Re planning application 3/2024/0613

**PROPOSED DEMOLITION OF EXISTING SINGLE GARAGE AND CONSTRUCTION OF NEW SINGLE-STOREY TWO-BEDROOM DWELLING.  
INGLEMEAD, WADDINGTON ROAD, CLITHEROE, BB7 2HN**

**Planning Application Objection (Highways)**

5 Street Elevation
Scale: 1:100

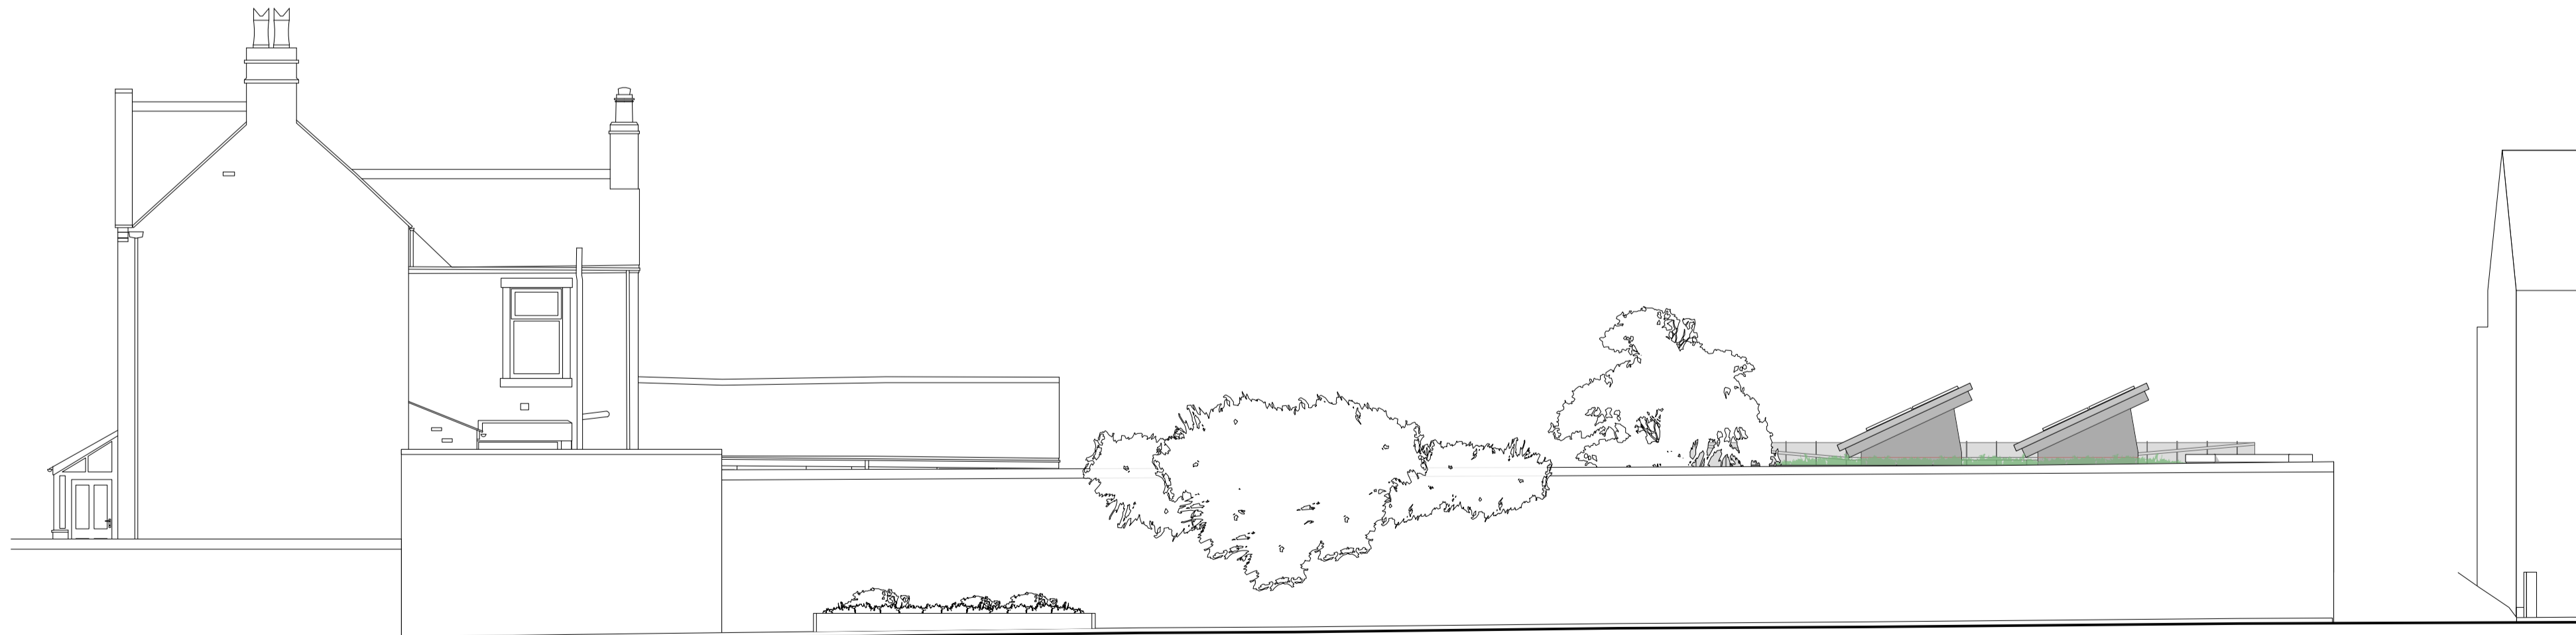
3. The design and construction materials are incongruous and out of character in a road of Victorian and Edwardian properties and reduces the local amenity. The established street scene is quite unique which the residents enjoy. In the Design and Access Statement by Stanton Andrews July 2024 section 4.2, the description of the dwelling is stated “a simple zinc box” and is incongruous. There appears to be errors in measurement of the future of the garden wall running alongside Hawthorne Place. The Design and Access Statement by Stanton Andrews July 2020 states that this wall will provide “very little of the proposed dwelling visible above the wall from street level.” The height of this wall decreases as it progresses down Hawthorne Place to a height of 2.85m not 3.1m at the entrance to the unadopted ginnel at the rear of Inglemead’s garden. The proposed finished floor level for the dwelling is 79.00 m (above sea level), the street level is 78.30m a difference of 70 cm. The proposed dwelling has eaves height of 3m and the ridge height of 4.1m. This will increase the visual impact from street level beyond that described in the planning statement. I object that both the eaves and ridge will be clearly visible.

The proposed entrance of this incongruous dwelling is also clearly visible from the street. I object to this resulting visual impact of a zinc building on the present street scene.

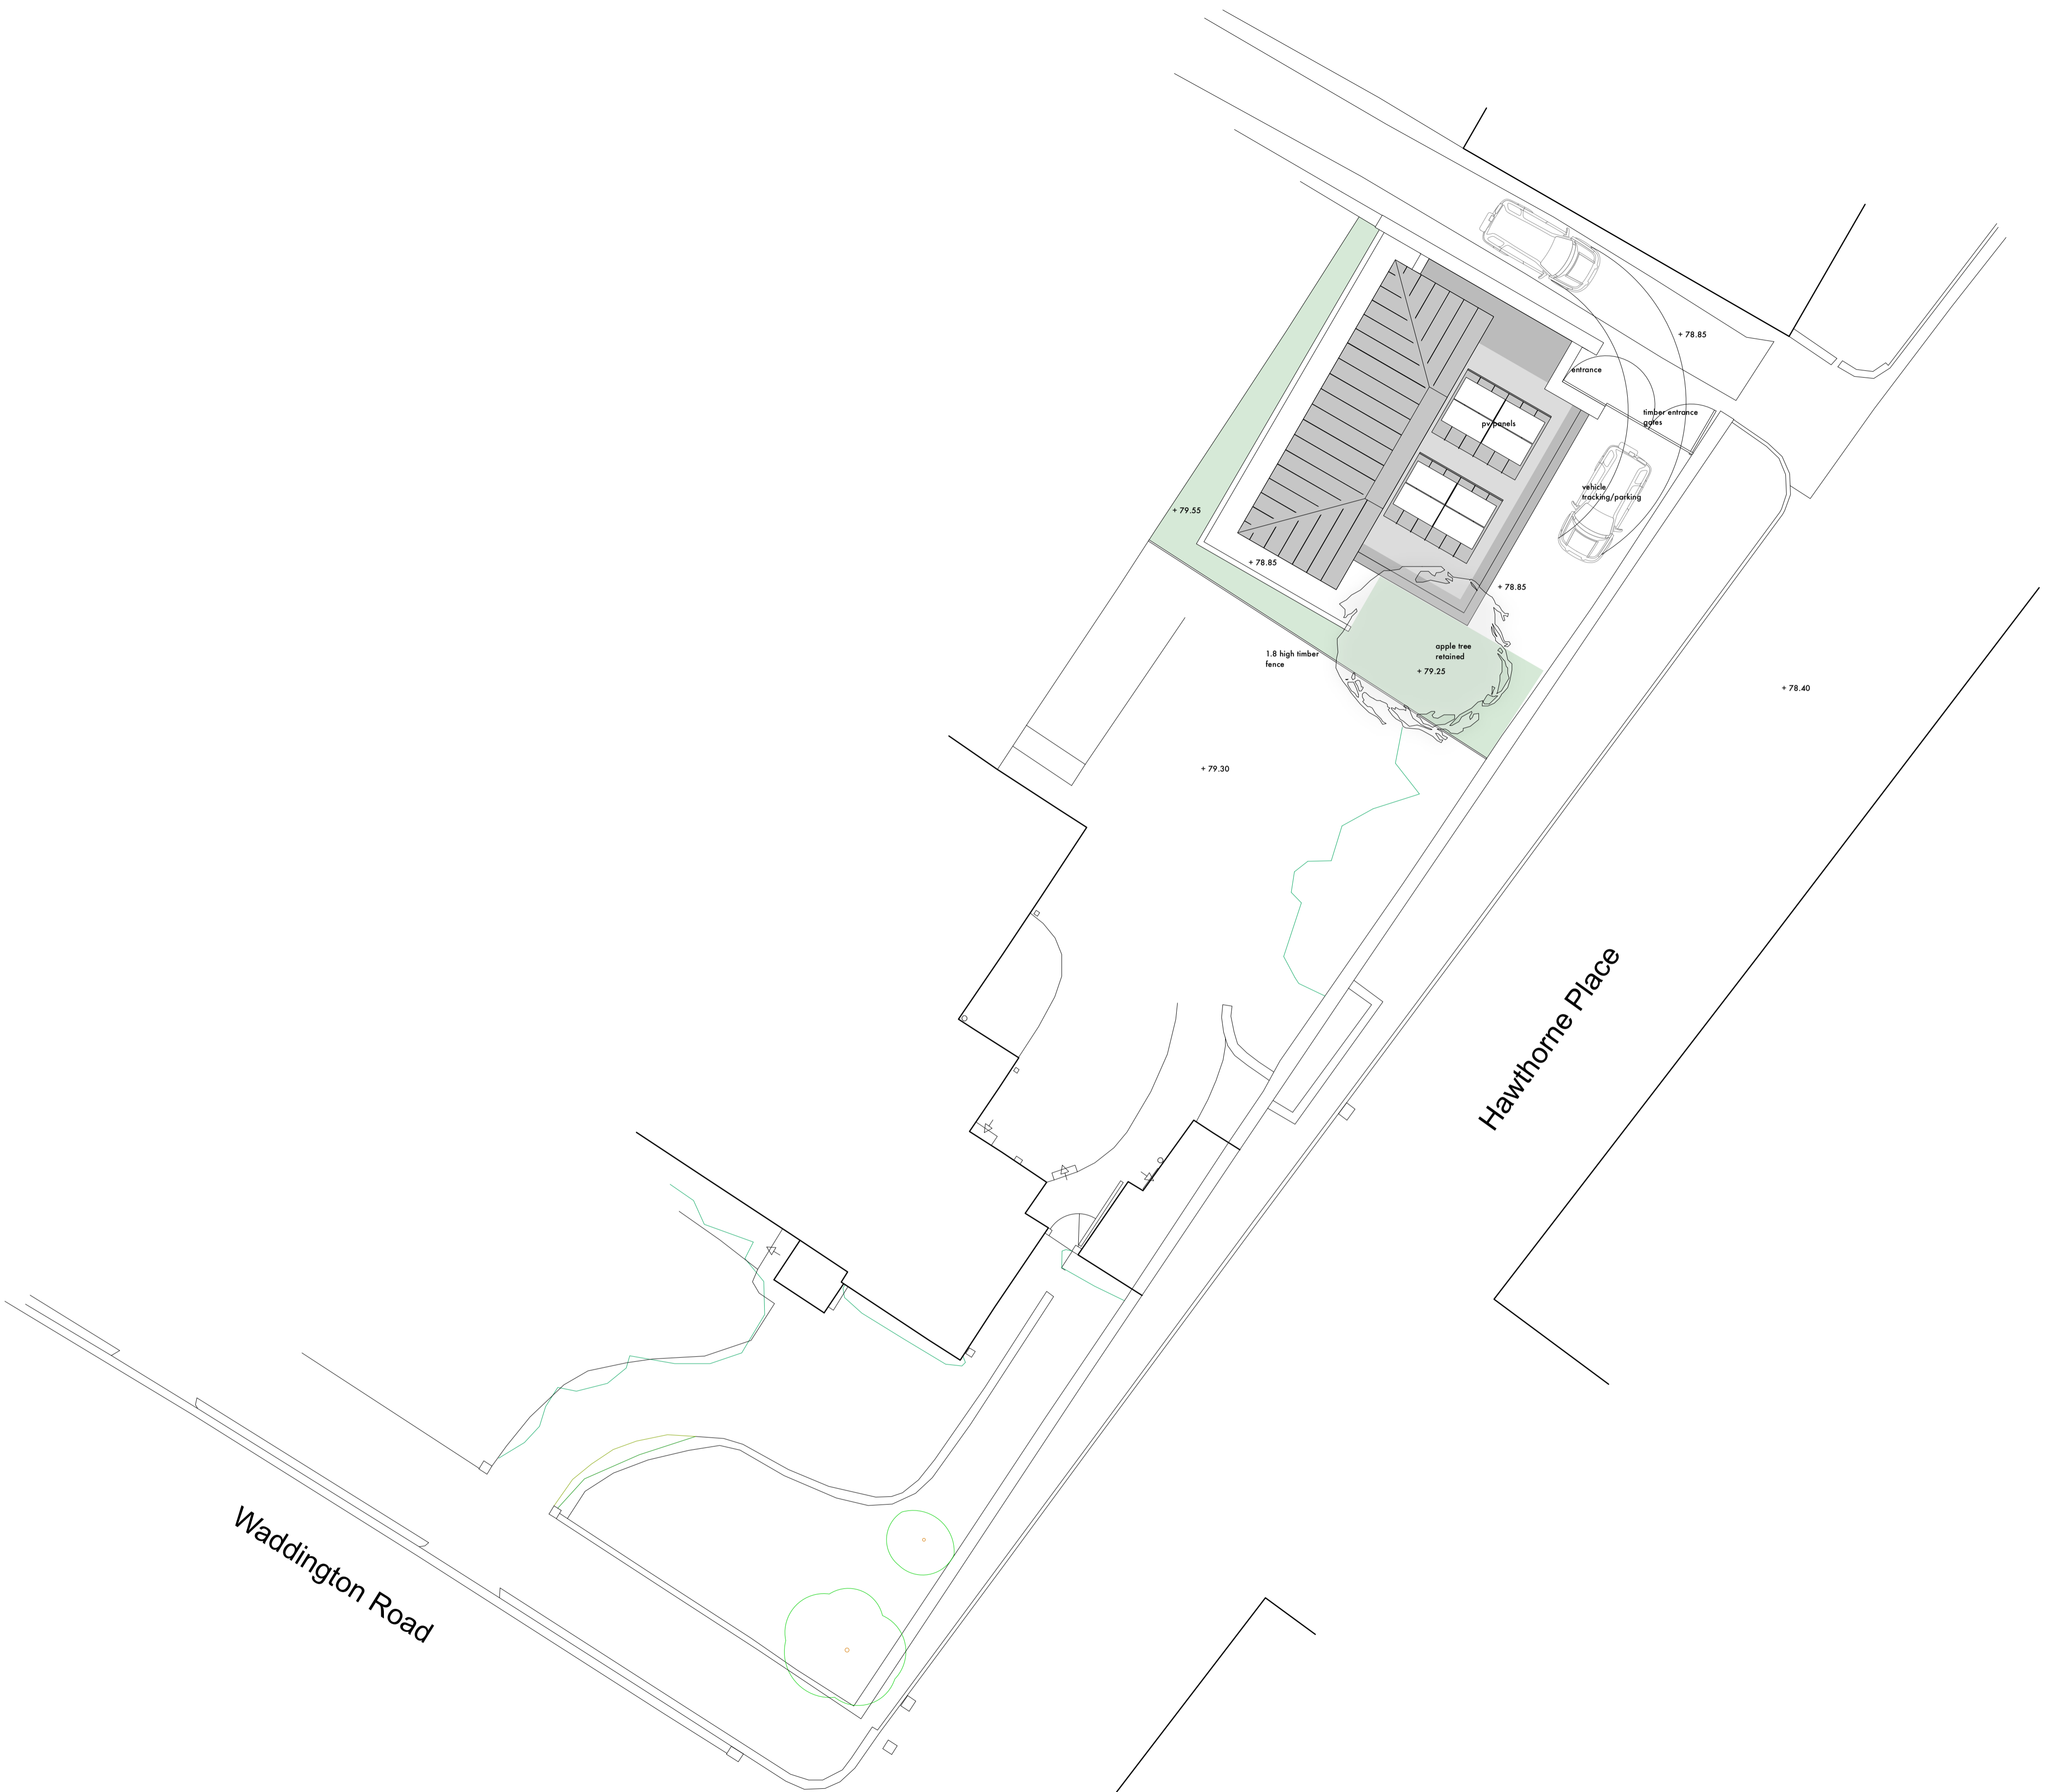
The distance between the perpendicular configuration between the [REDACTED] [REDACTED] is far below the expected clearance of 6m. There has been no swept path analysis performed at the proposed access point to demonstrate how vehicles are able to enter and leave the driveway, let alone in a forward gear.

There has been no consideration to the restricted width of the back-alley, or the 45° visibility splays required for the proposed residential driveway required between the highway boundary and points on either side of the drive measured 3m back from the nearside edge of the footway. The boundary wall which is said to require significant maintenance is now proposed to screen the development as opposed to be reduced to being reduced in height to support the required visibility splays.

The submitted planning application demonstrates how vehicles are proposed as either entering the back-alley in a forward gear via Eastham Street, or in reverse gear from Hawthorne place, neither should be considered acceptable.
